Re: Marysville Corporate Center BSP – *Final Review 1*  
PA22004

After reviewing the application Final Binding Site Plan (BSP) application materials for the above referenced proposal, the following technical review comments are provided below.

**FINAL BSP Amendments**

INDEX DATA: SEC 28-33 T 31N R 5E WM
SURVEY FOR: PACIFIC REALTY ASSOCIATES, L.P. 15908 47TH AVE NE MARYSVILLE, WA 98271
SNOHOMISH COUNTY, WASHINGTON
SHEET 6 OF 13

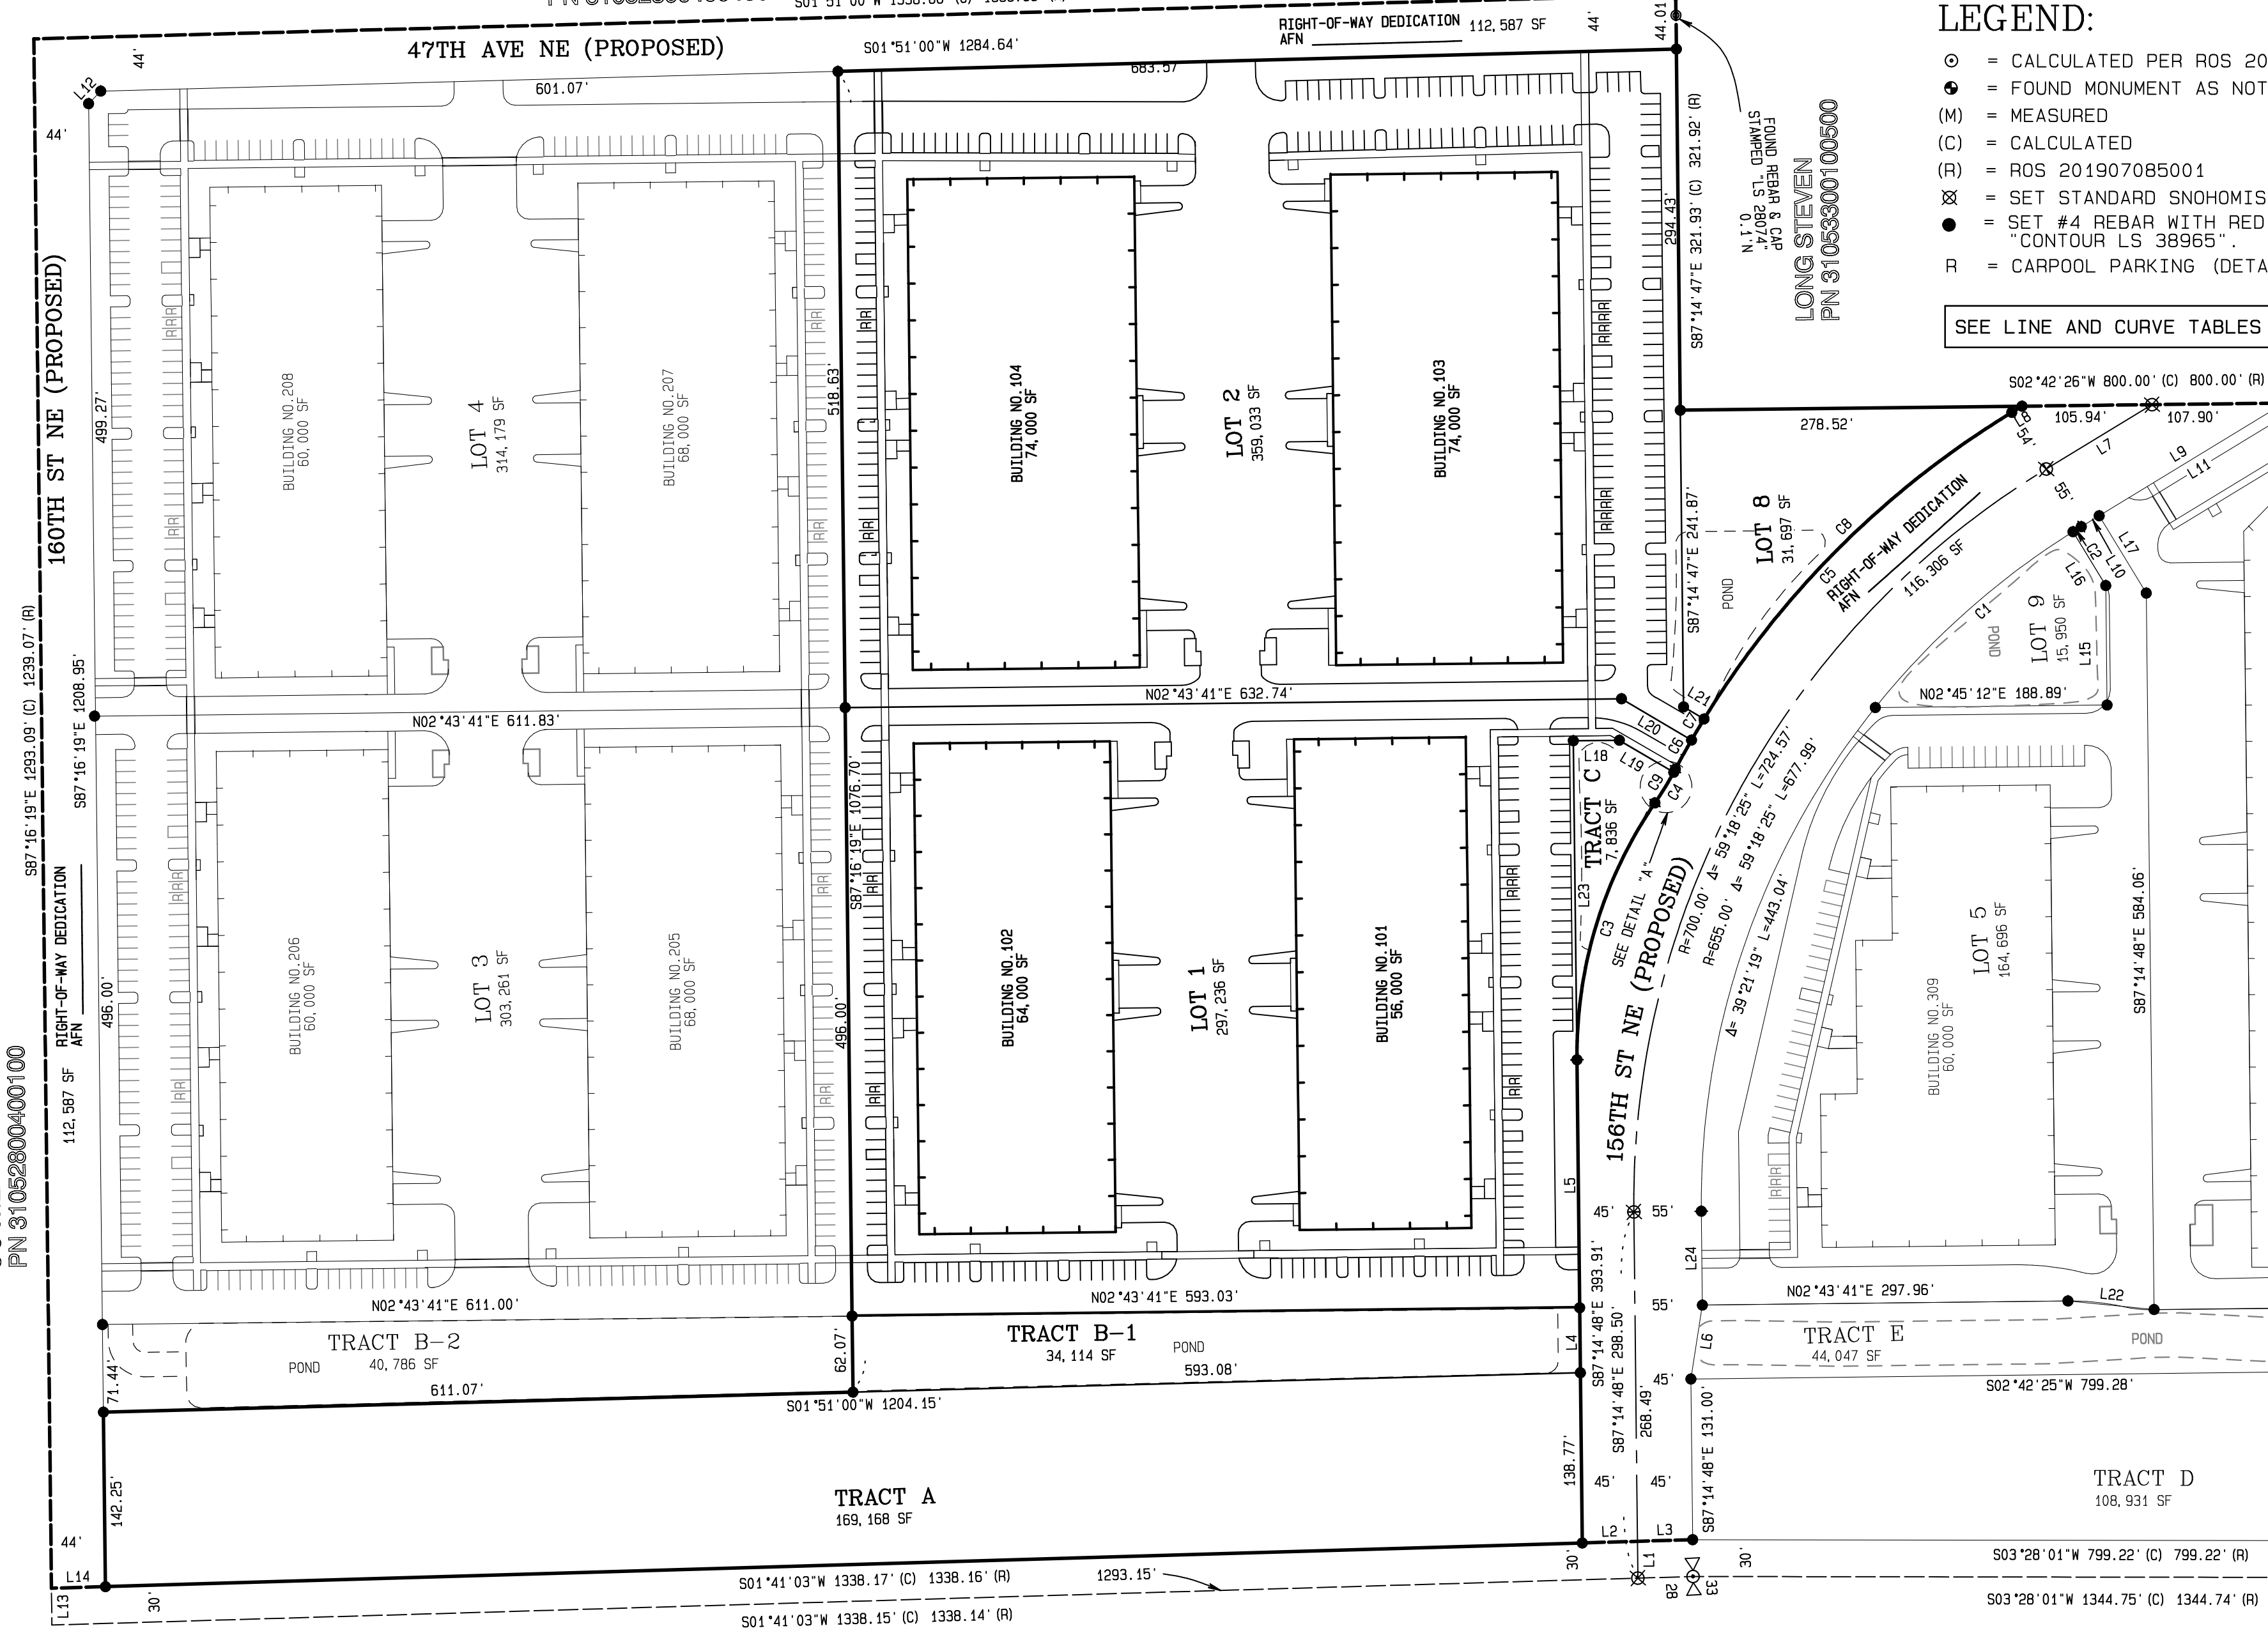
5. Sheet 6 of 13:
- a. Remove "PROPOSED IMPROVEMENT."

- b. Remove "RIGHT-OF-WAY DEDICATION AFN \_\_\_\_\_."
  - c. Remove 156<sup>TH</sup> ST NE (~~PROPOSED~~), and amend to read "156<sup>TH</sup> ST NE (HEREBY DEDICATED PUBLIC RIGHT OF WAY)".

- d. Remove the proposed building pads, parking areas and swale from lot 5. Only the lot lines should be shown.
  - e. Remove the proposed building pads, parking areas and swale from lot 6. Only the lot lines should be shown.

- f. Remove the swale from Tract D, E, F & H. Only the tract lines should be shown.
  - g. Remove reference to parking stall dimensions.
6. Sheet 7 of 13:

INDEX DATA:	SEC 28-33 T 31N R 5E WM
SURVEY FOR:	PACIFIC REALTY ASSOCIATES, L.P. 15908 47TH AVE NE MARYSVILLE, WA 98271
SNOHOMISH COUNTY, WASHINGTON	
SHEET 7 OF 13

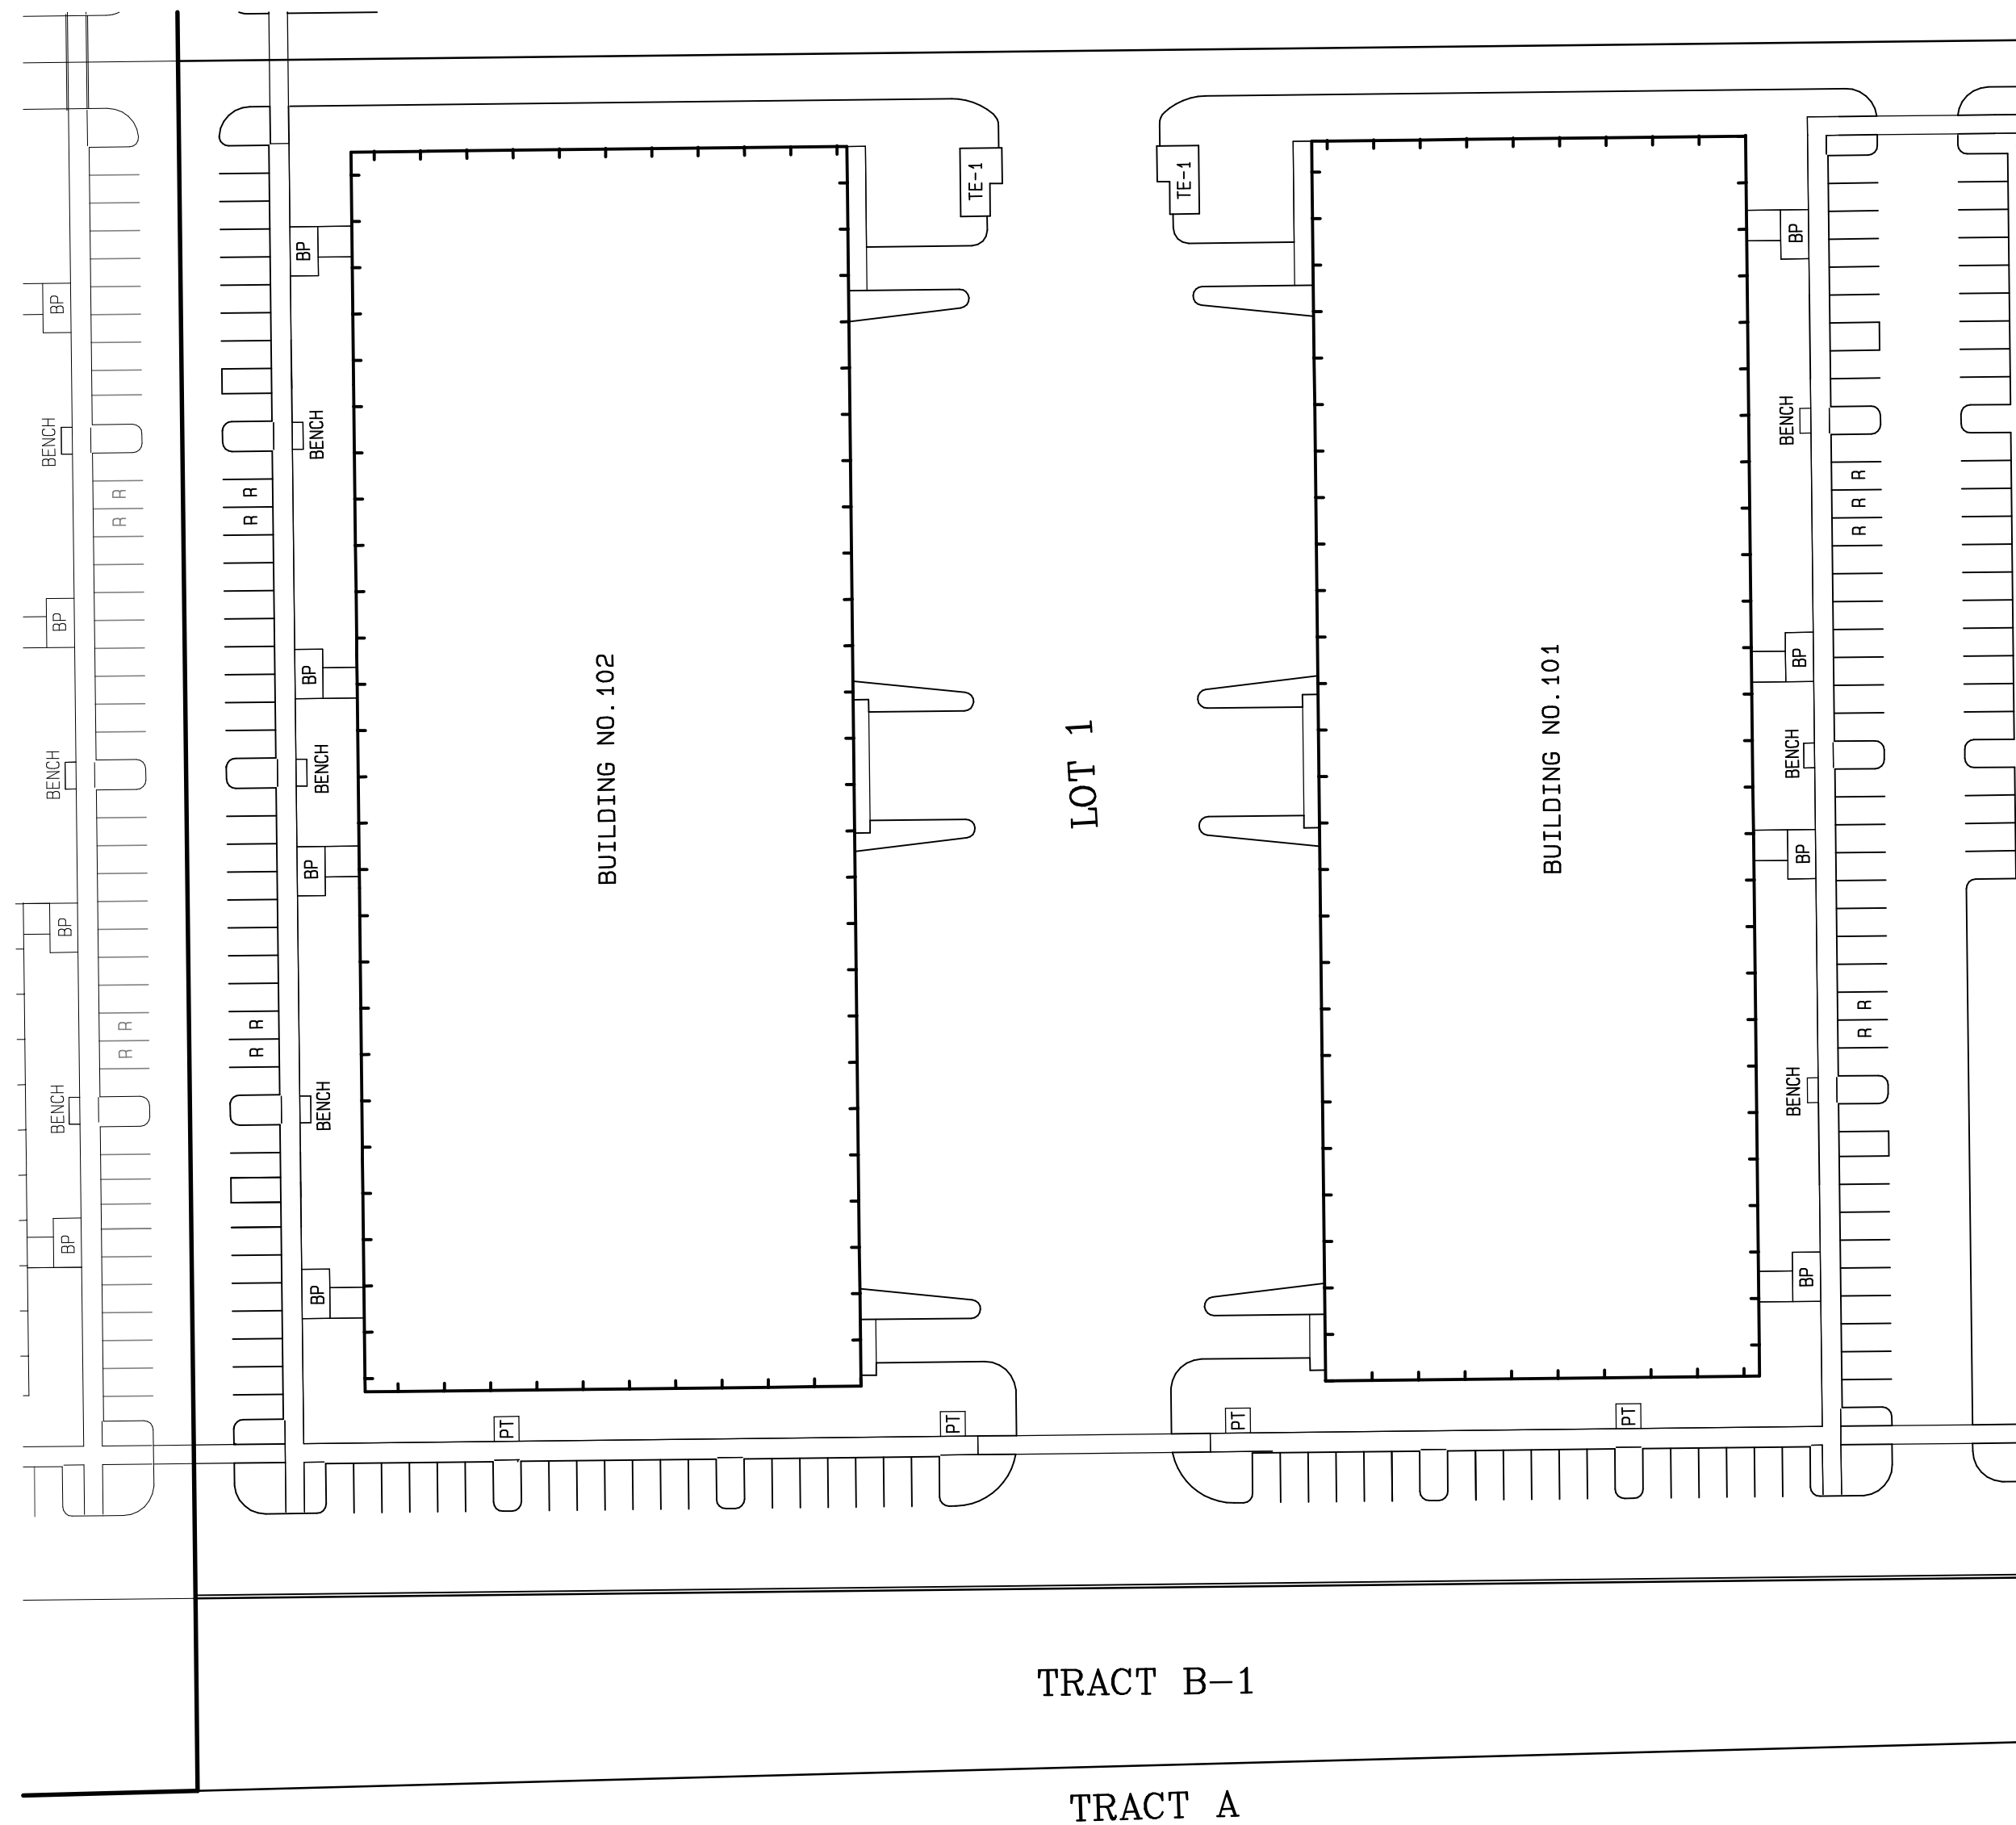
- a. Remove "PROPOSED IMPROVEMENT."
  - b. Bold the Lot Lines for all Lots and Tracts.
  - c. Remove "RIGHT-OF-WAY DEDICATION AFN \_\_\_\_\_," for both 156<sup>TH</sup> ST NE, 160<sup>TH</sup> ST NE AND 47<sup>TH</sup> AVE NE.

- d. Remove 156<sup>TH</sup> ST NE (~~PROPOSED~~), and amend to read "156<sup>TH</sup> ST NE (HEREBY DEDICATED PUBLIC RIGHT OF WAY)".
  - e. Remove 160<sup>TH</sup> ST NE (~~PROPOSED~~), and amend to read "160<sup>TH</sup> ST NE (HEREBY DEDICATED PUBLIC RIGHT OF WAY)".

- f. Remove 47<sup>TH</sup> AVE NE (~~PROPOSED~~), and amend to read "47<sup>TH</sup> AVE NE (HEREBY DEDICATED PUBLIC RIGHT OF WAY)".
  - g. Remove the proposed building pads and parking areas from lot 1. Only the lot lines should be shown.

- h. Remove the proposed building pads and parking areas from lot 2. Only the lot lines should be shown.
  - i. Remove the proposed building pads, parking areas and swale from lot 5. Only the lot lines should be shown.

- j. Remove the swale from Lot 4. Only the lot lines should be shown.
  - k. Remove the swales from Tracts B, C, D, E, F & G. Only the tract lines should be shown.

- l. Remove reference to parking stall dimensions.
7. Sheet 8 of 13:
- a. Remove 156<sup>TH</sup> ST NE (~~PROPOSED~~), and amend to read "156<sup>TH</sup> ST NE (HEREBY DEDICATED PUBLIC RIGHT OF WAY)".

23. Detail "A" on sheet 7 of the BSP map is incorrectly labeled C19. This should read C9.
